**Ponderosa Filing No. 3 at Lorson Ranch I, PUDSP-19-010**

**Please accept the following comments from El Paso County Public Health regarding the project referenced above:**

**Mike McCarthy**  
**El Paso County Public Health**  
**719-575-8602**  
**[mikemccarthy@elpasoco.com](mailto:mikemccarthy@elpasoco.com)**  
**30Jan2020**

DEVELOPED CONDITIONS DRAINAGE PLAN
PONDEROSA at LORSON RANCH
FILING NO. 3

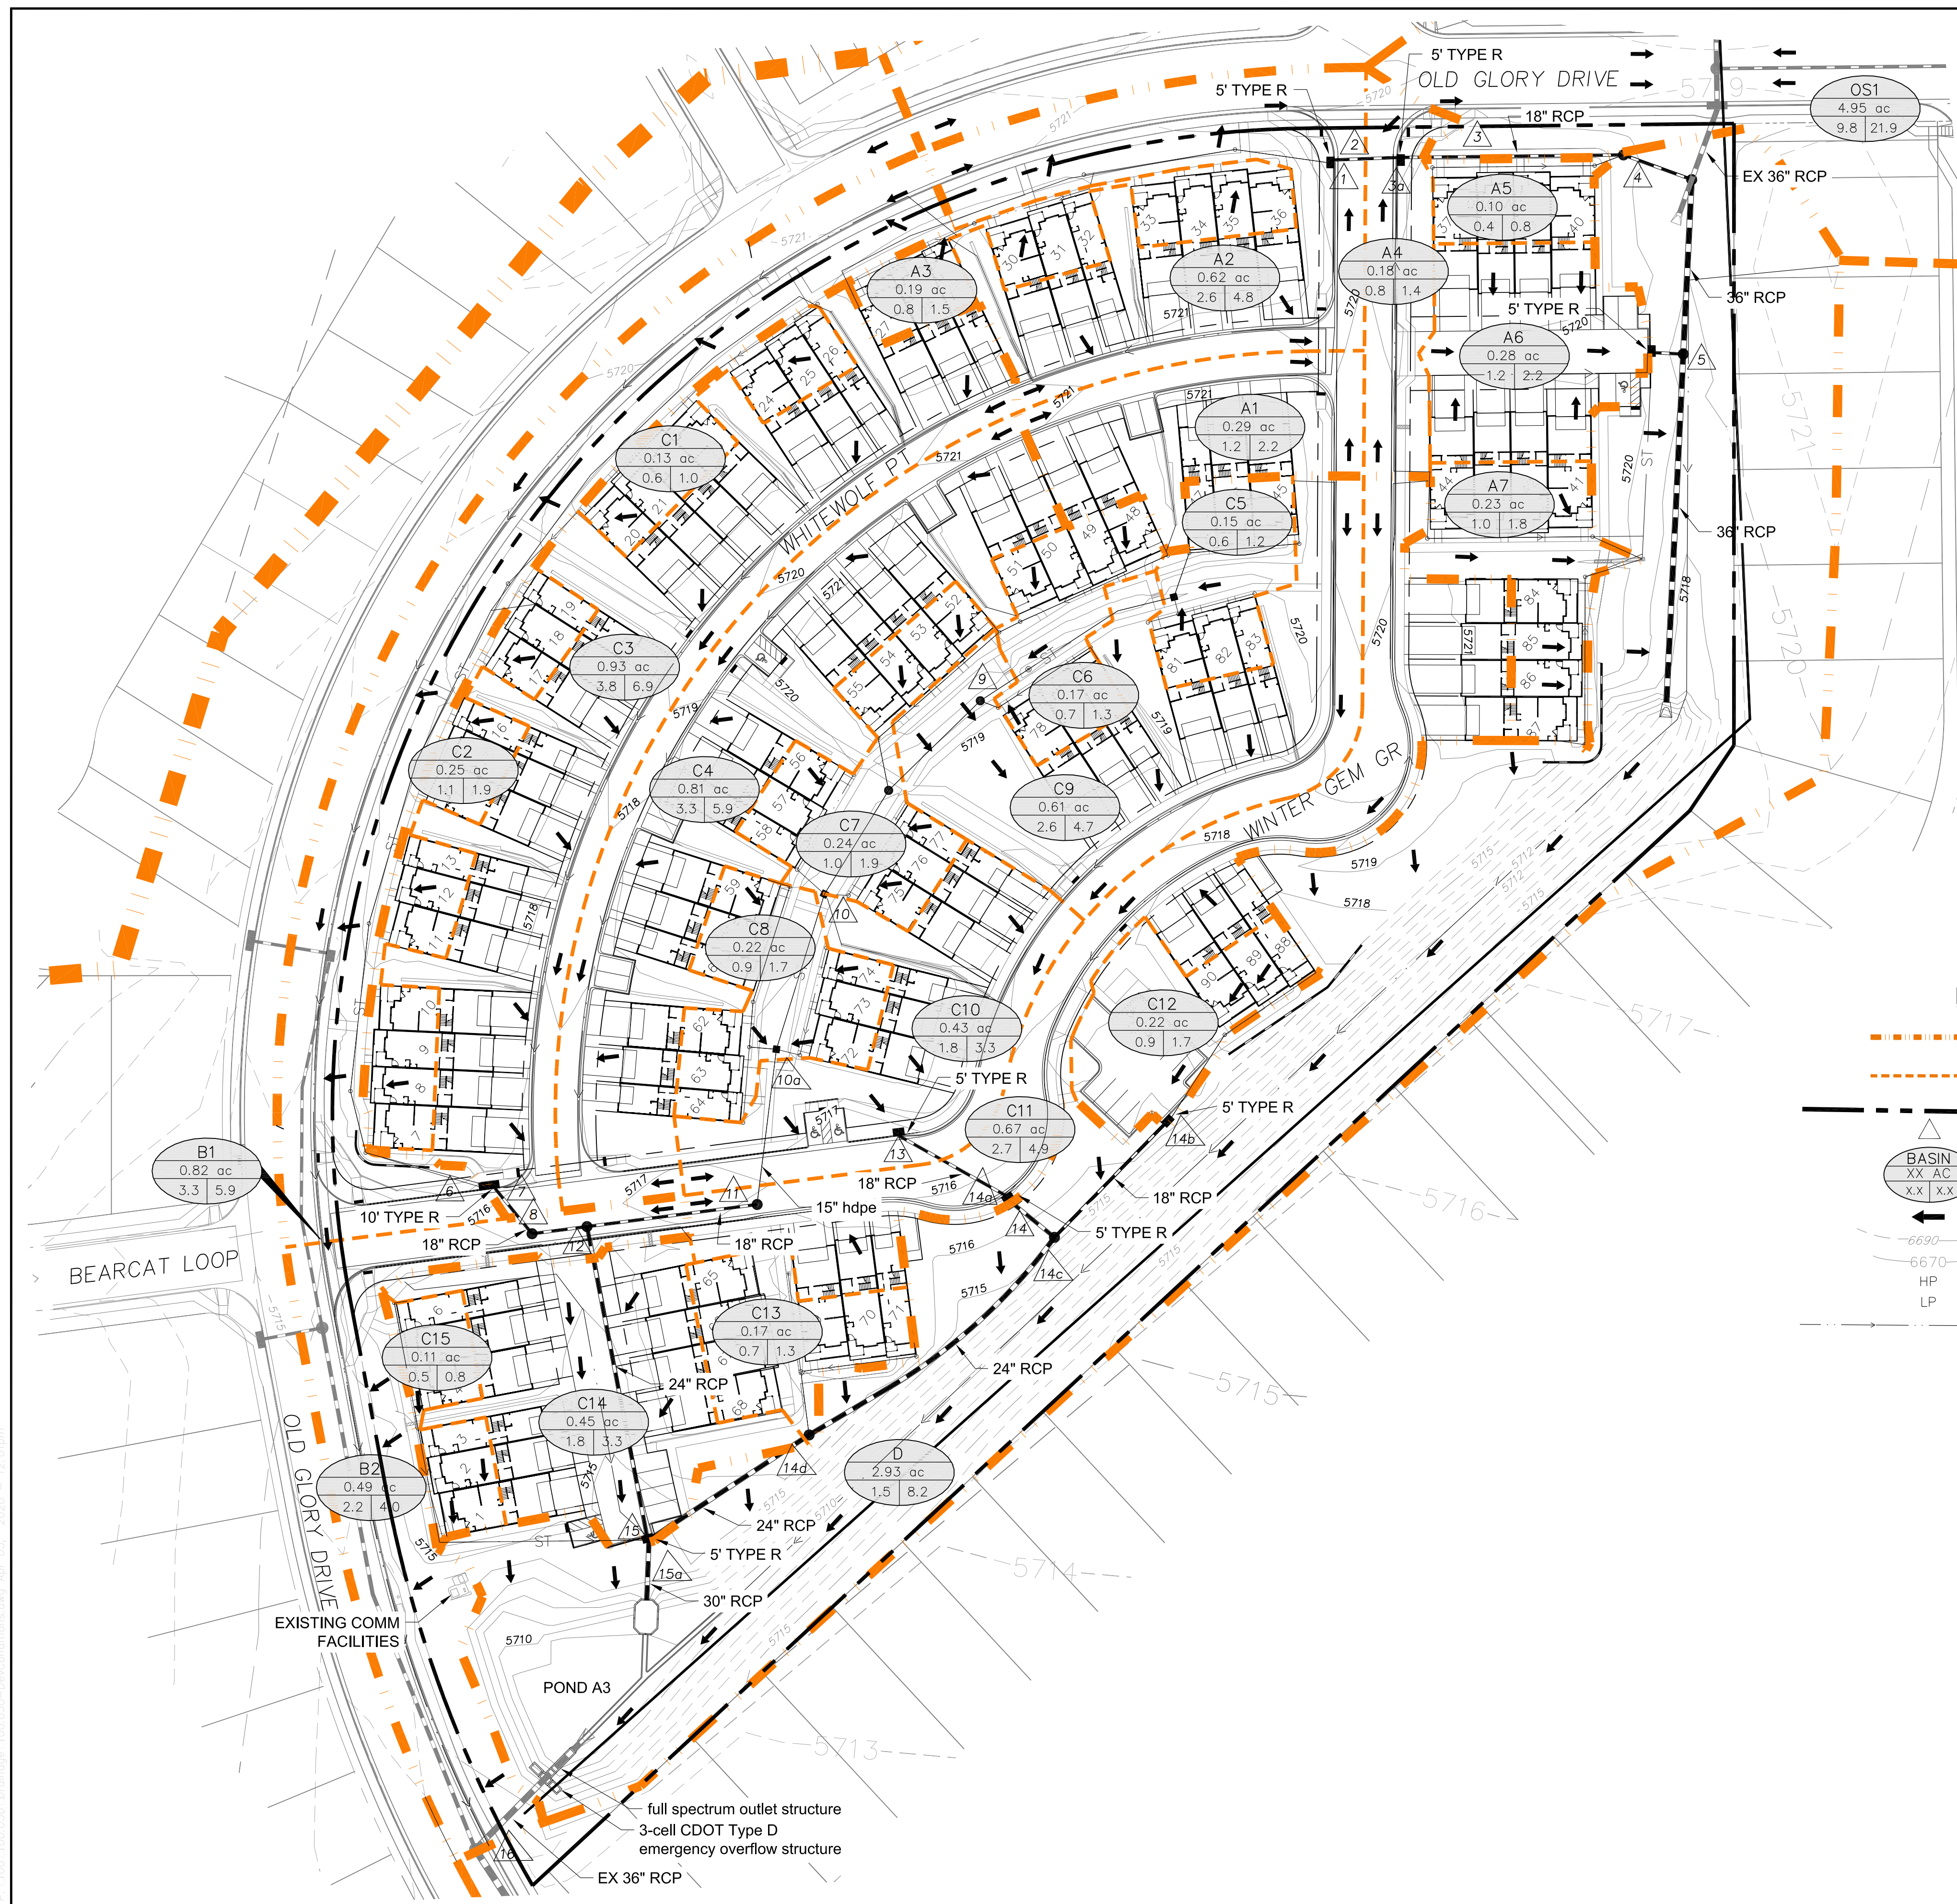
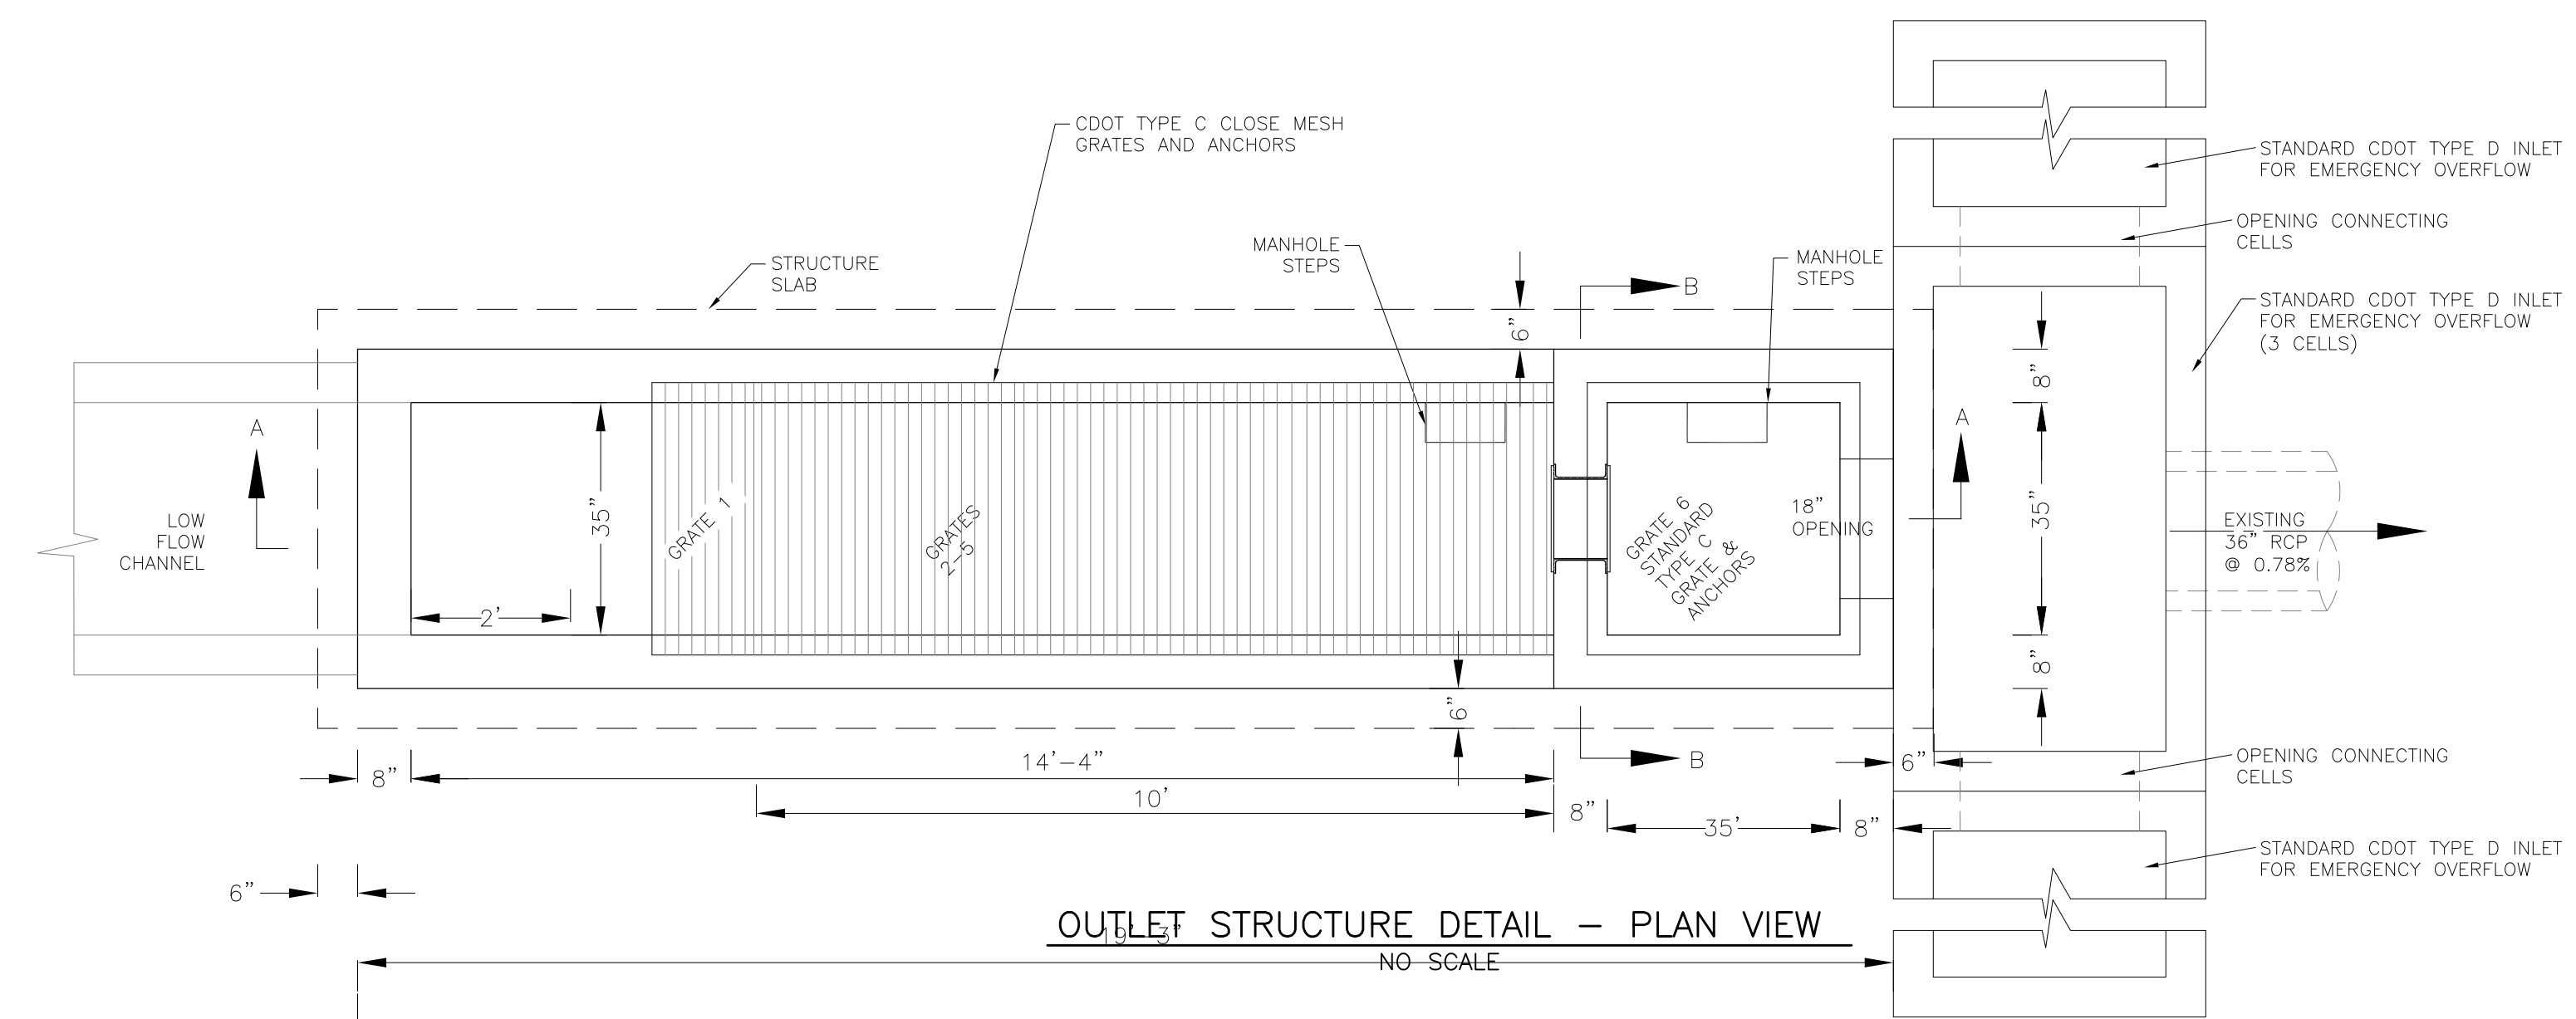
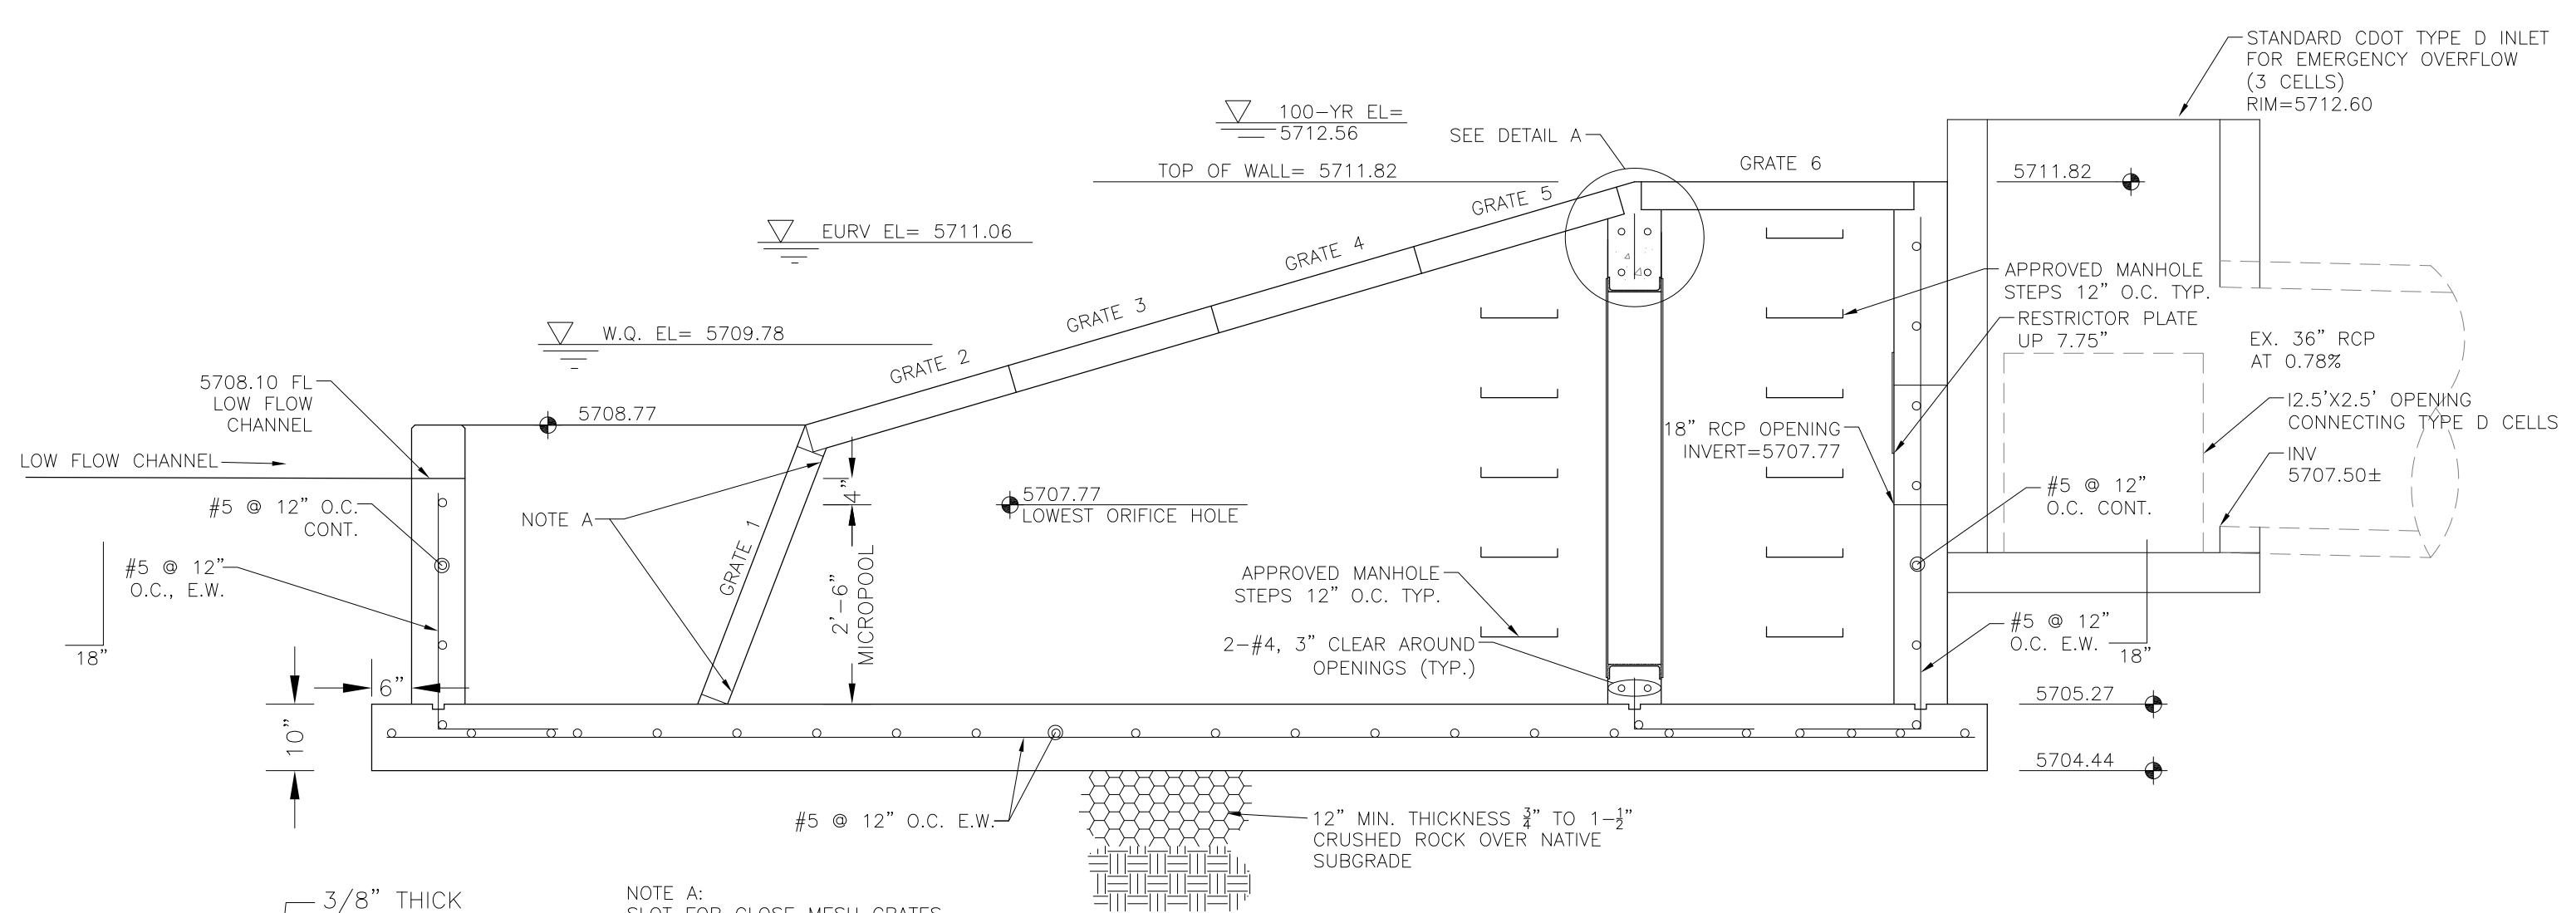
- The water quality basins must have mosquito control responsibilities included as a part of the construction design and Lorson Ranch Metropolitan District maintenance plan to help control mosquito breeding habitat and minimize the potential for West Nile Virus.
